Project Name: RAYNOLDS ADDITION

**CITY OF ALBUQUERQUE
PLANNING DEPARTMENT
September 24, 2014
DRB Comments**

PROJECT # 1010231 APPLICATION # 14-70320

RE: Lots 7 - 9, Block 38, Raynolds Addition

SUBDIVISION PLAT OF
LOT 7-A & LOT 8-A
BEING A RE-PLAT OF LOTS 7,8 &
THE EASTERLY PORTION OF LOT 9
BLOCK 38, RAYNOLDS ADDITION
PROJECTED SECTION 19 & 20, T 10 N, R 3 E, N.M.P.M.
TOWN OF ALBUQUERQUE GRANT
ALBUQUERQUE, BERNALILLO COUNTY, NEW MEXICO
SEPTEMBER, 2014

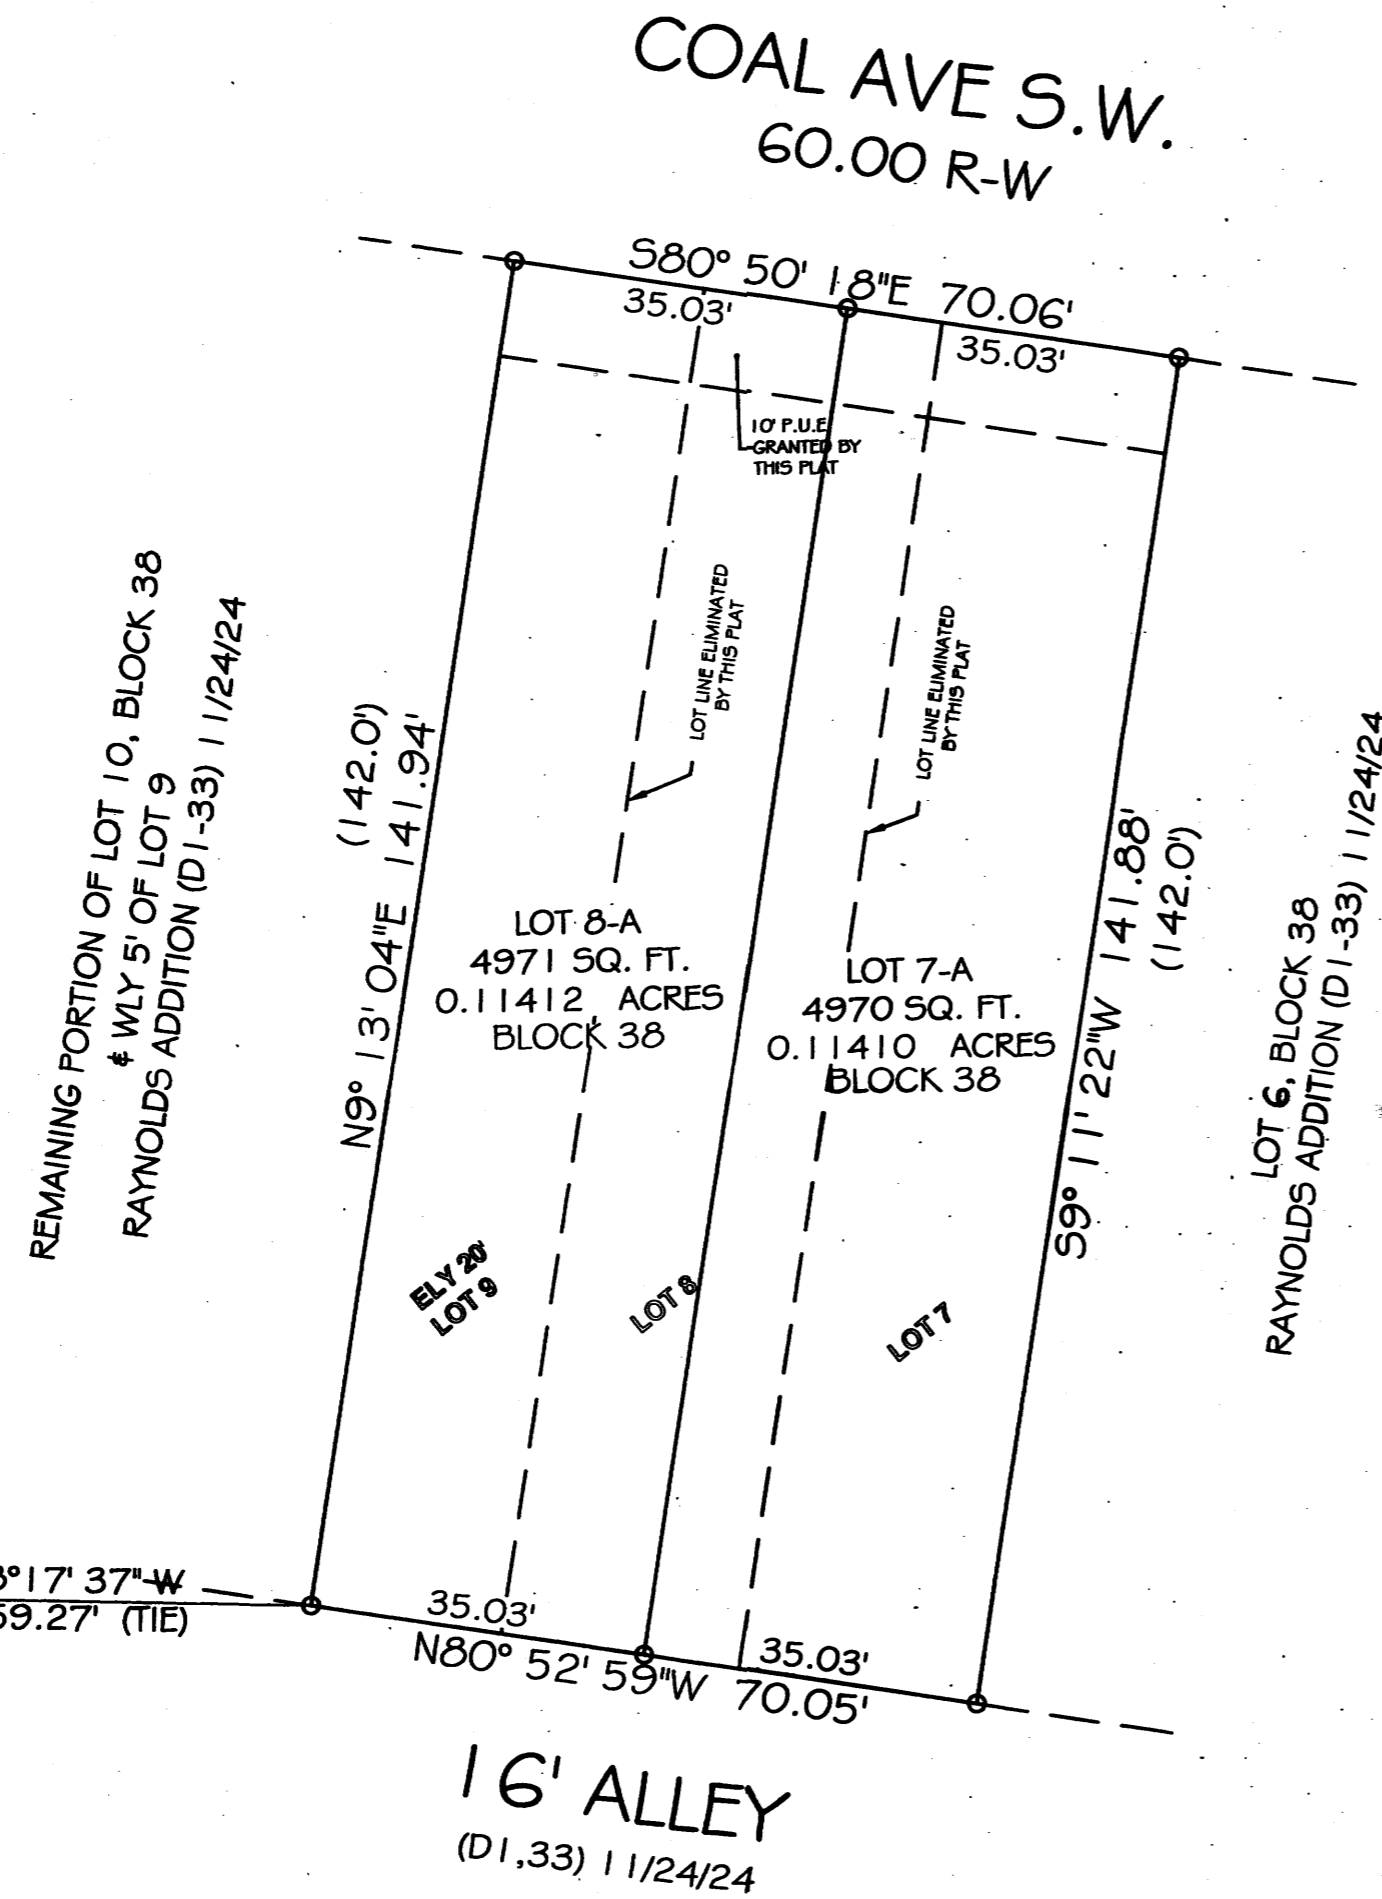
The Location Map is illegible; please provide a vicinity map that identifies the site and nearby streets.
